# Comments for Planning Application 21/02839/PLF

Application Number: 21/02839/PLF

Address: Manor Farm Low Field Lane Haisthorpe East Riding Of Yorkshire YO25 4NX

Proposal: Erection of a lean-to extension to be used for agricultural machinery storage and repair

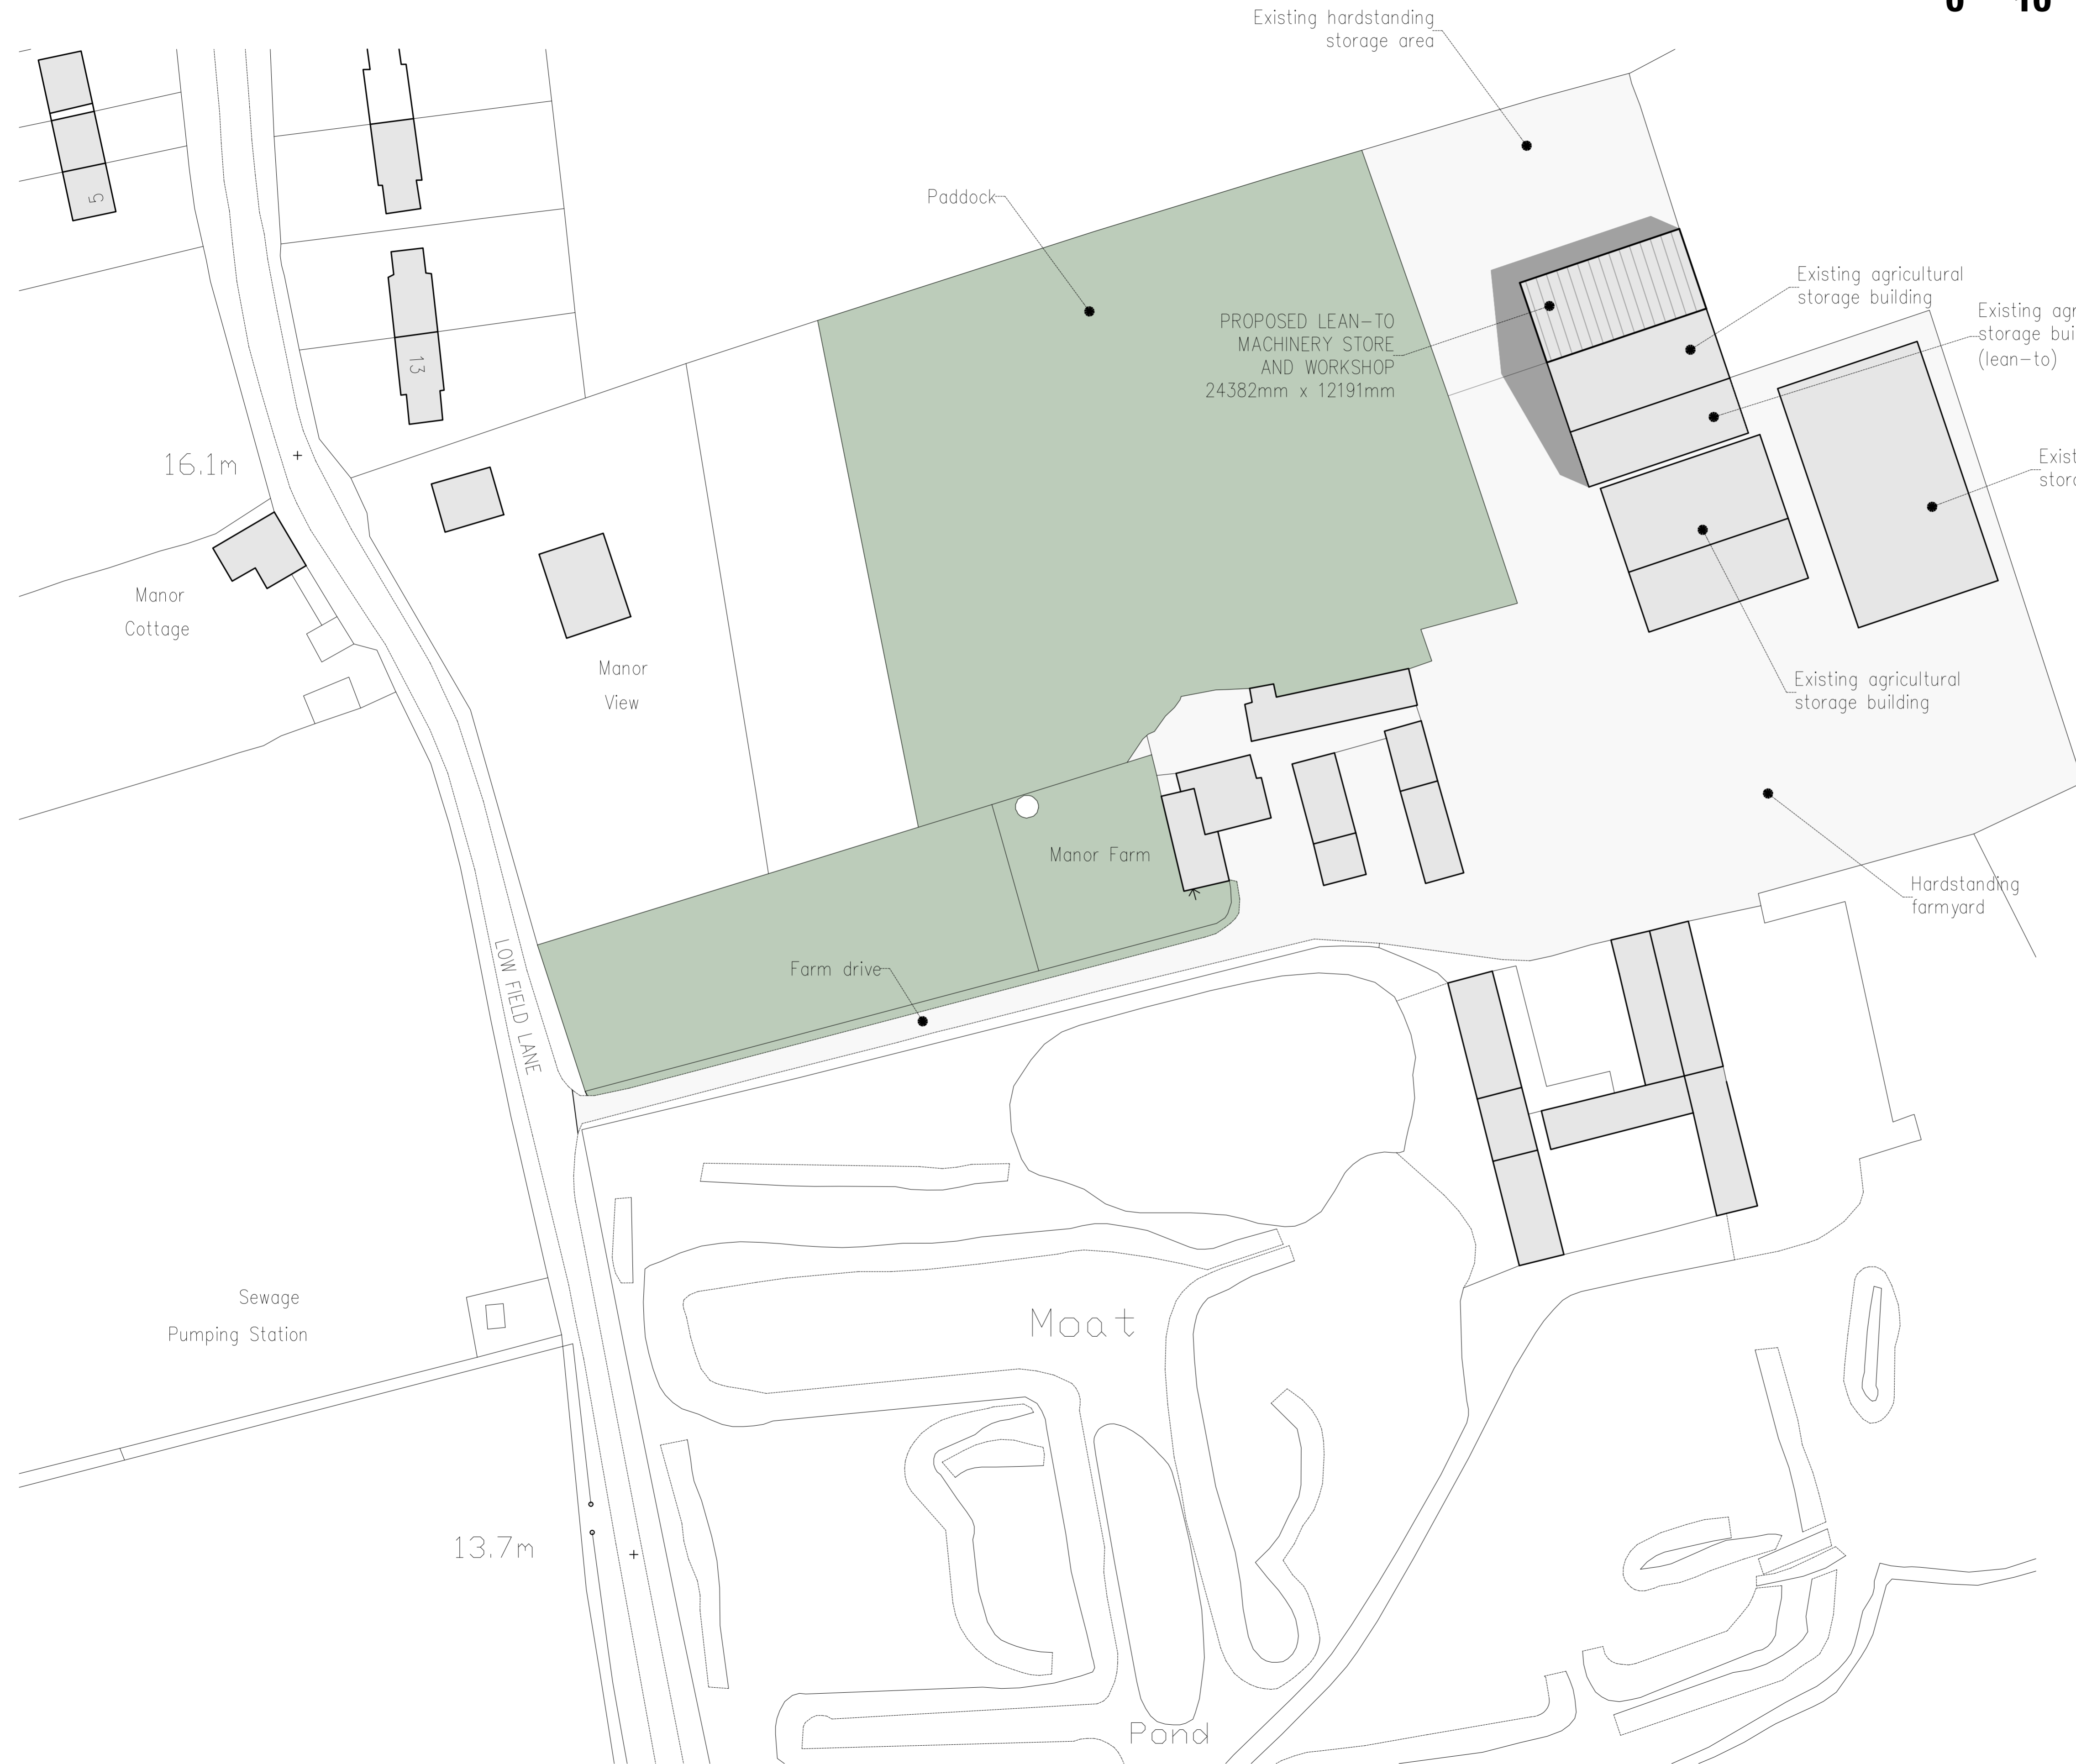
Layout The area identified for the new unit on site plan ( drawing No IP/MW/02) has been the site & main storage for the 1,800+ large crates. These images can be seen on various aerial photo sites, <https://eservices.l&registry.gov.uk/eservices/FindAProperty/view/MapEnquiryInit.do> & show the true history of the use of this land rather than the pre-application view created in recently moving these boxes adjacent to our home.
